**KIRKLEES METROPOLITAN COUNCIL
INVESTMENT & REGENERATION SERVICE**

DELEGATED DECISION TO DETERMINE PLANNING APPLICATIONS

Reference No: 2021/62/92658/E

Site Address: The Abbey, 171, Abbey Road, Shepley, Huddersfield,
HD8 8DY

Drawing Title
PROPOSED FLOOR PLAN,
ELEVATIONS & SITE PLAN

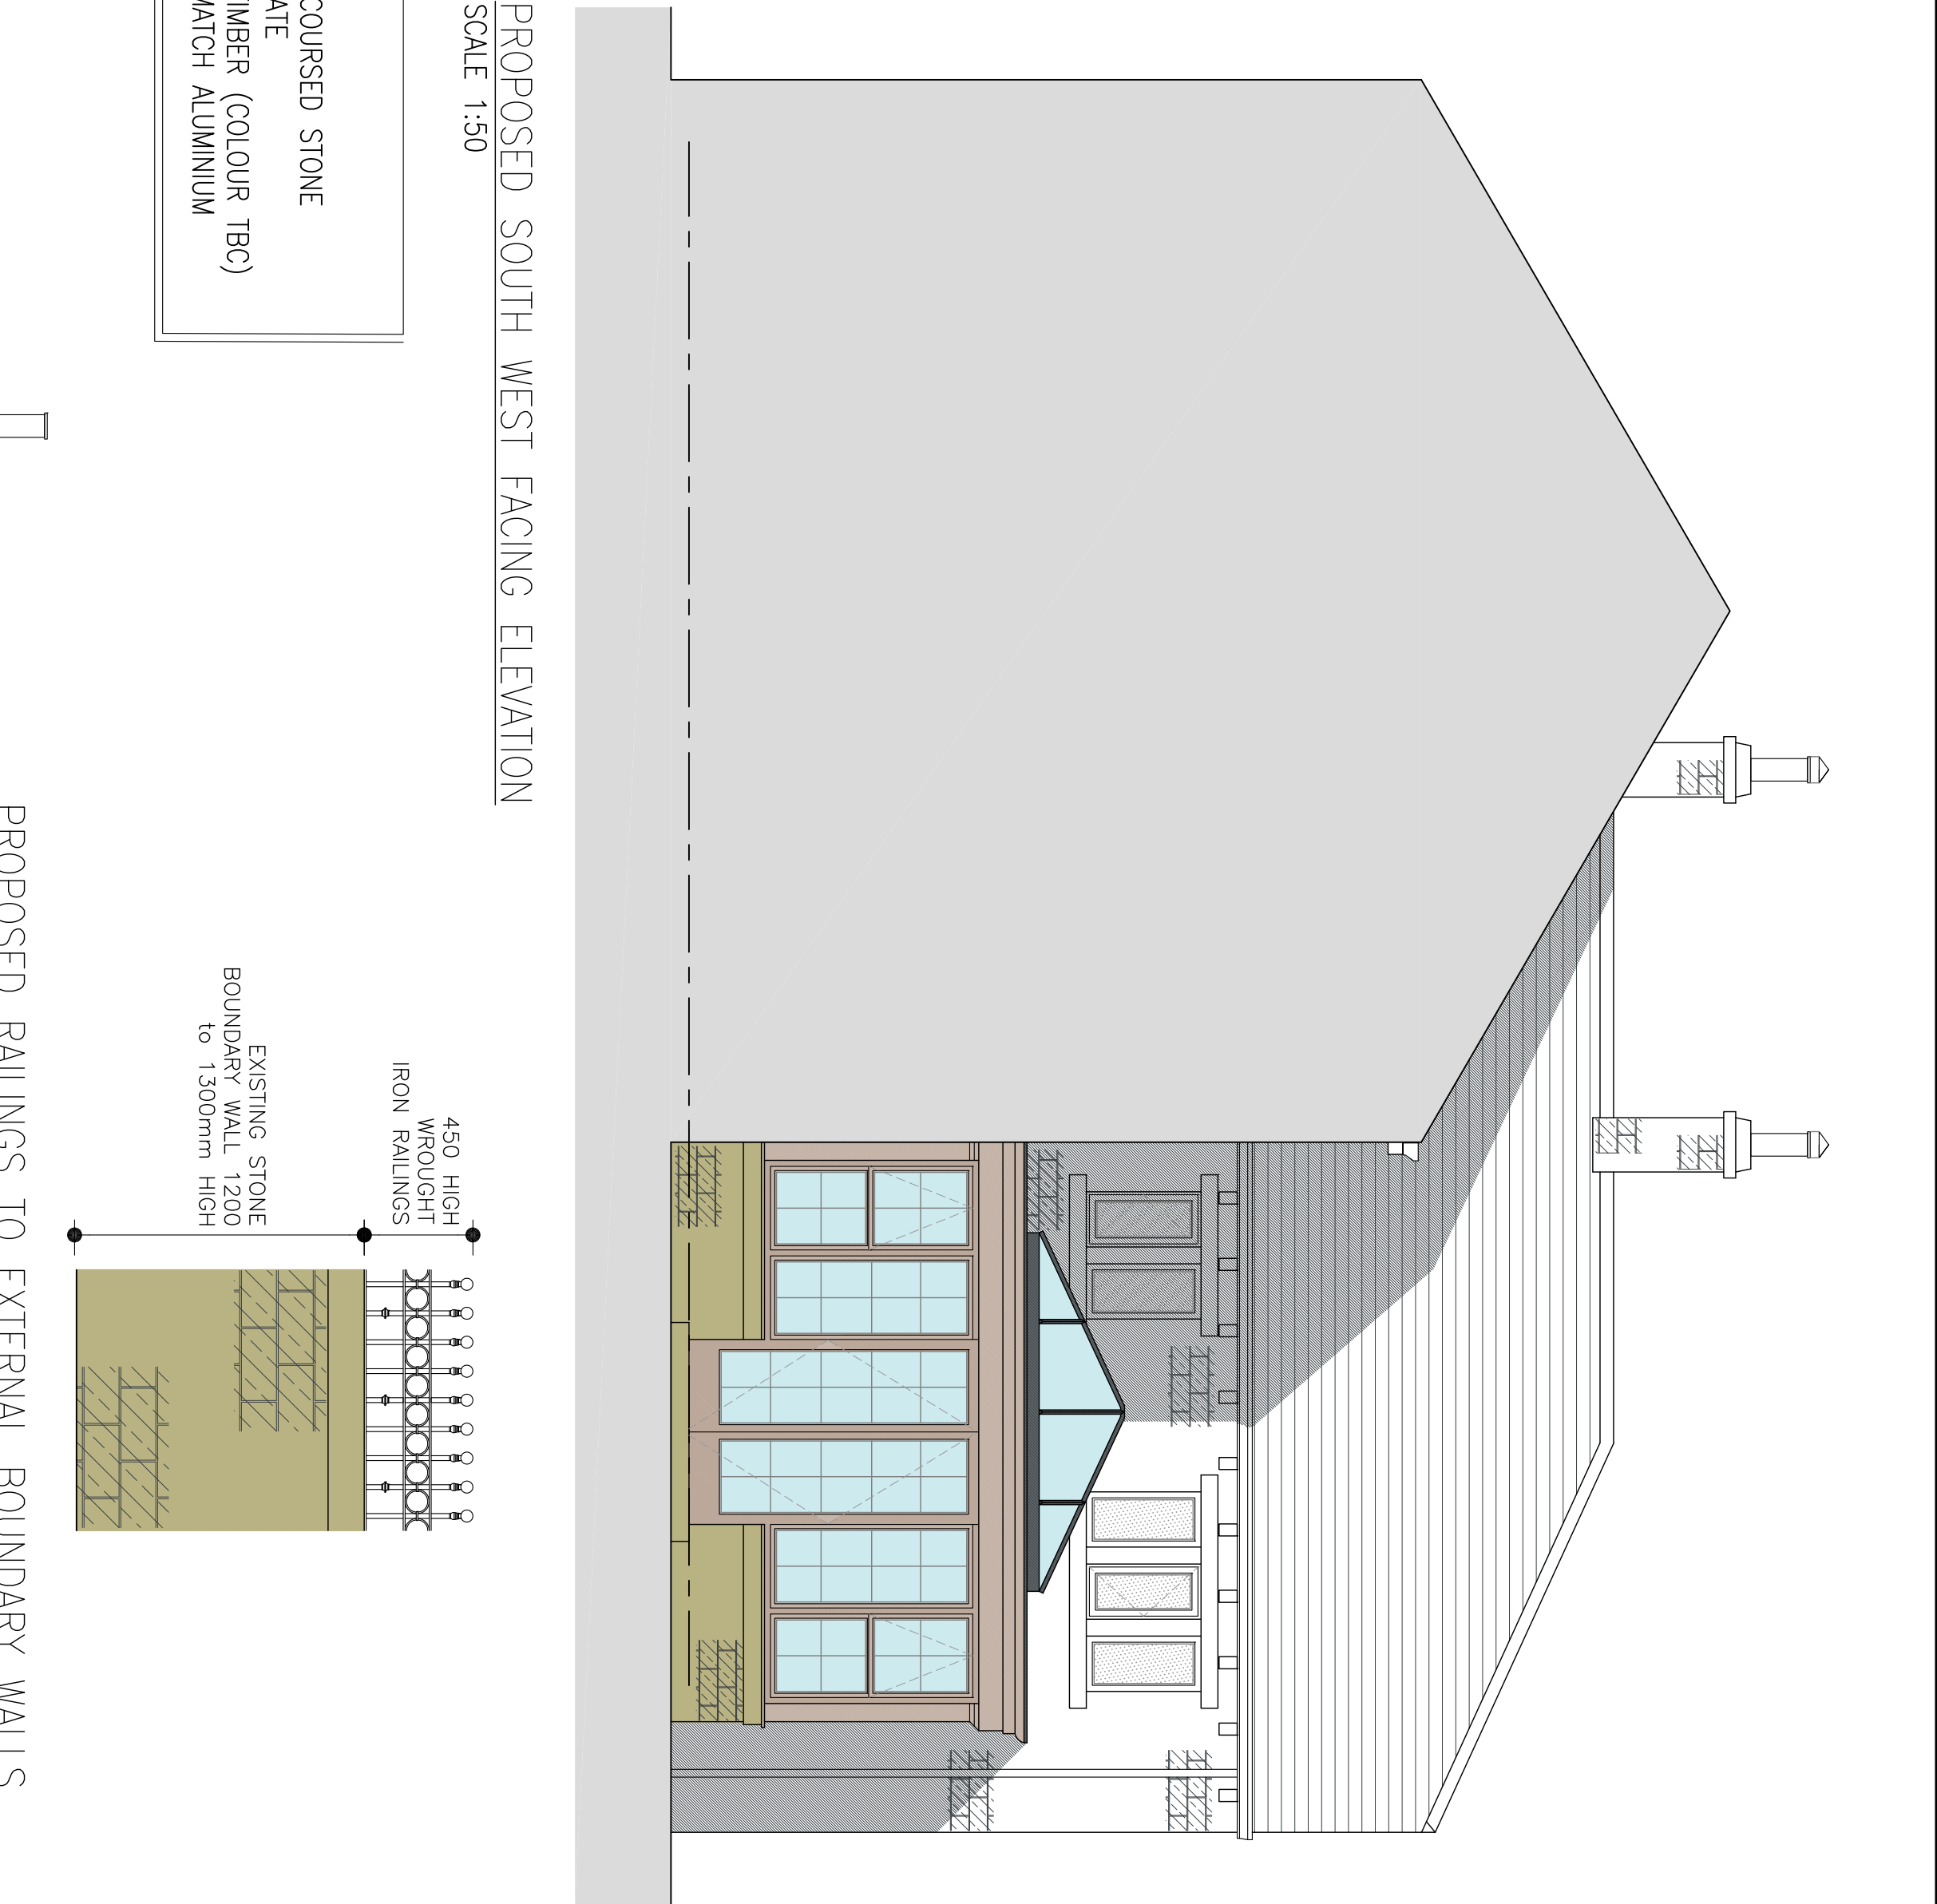
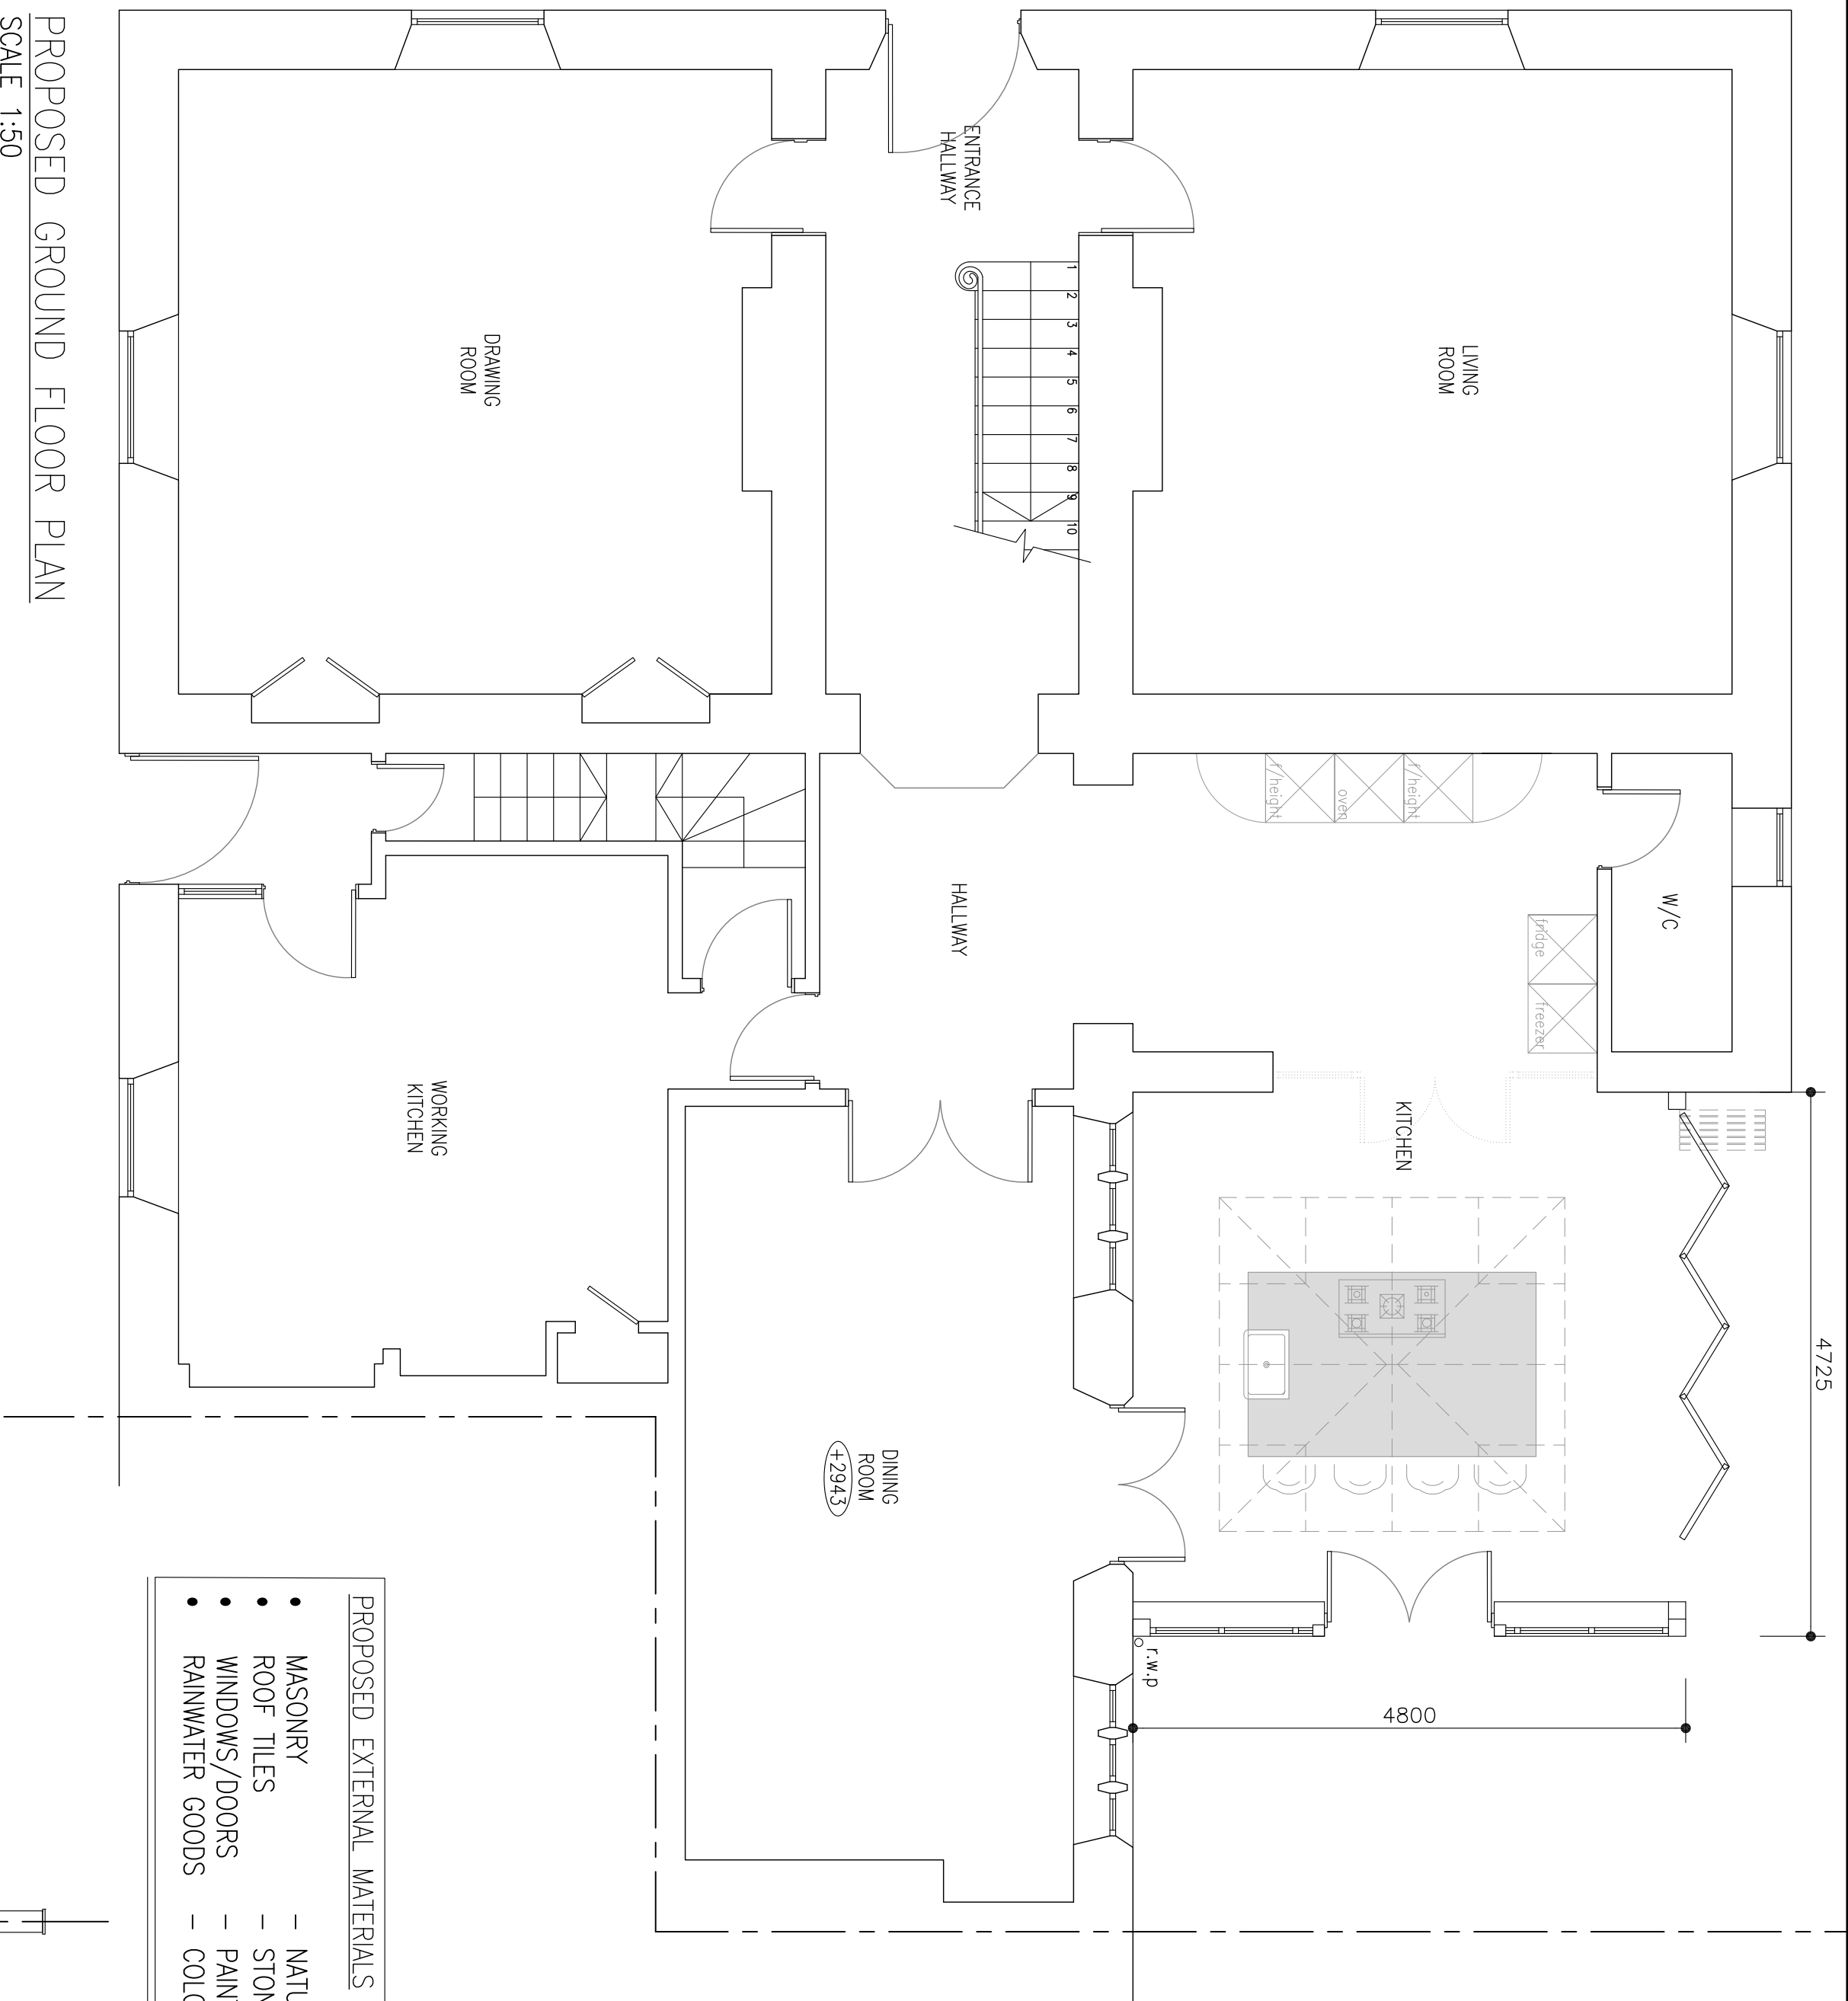
The KC Highways Development Management team asked that the first five metres of the access driveway be hard surfaced, so that loose chippings are not transferred onto the highway. The agent submitted amended plans demonstrating this, which are considered acceptable.

The KC Highways Development Management team requested that the first five metres of the access driveway be hard surfaced so that loose chippings would not be transferred onto the highway. The agent submitted amended plans demonstrating this, which are considered acceptable.
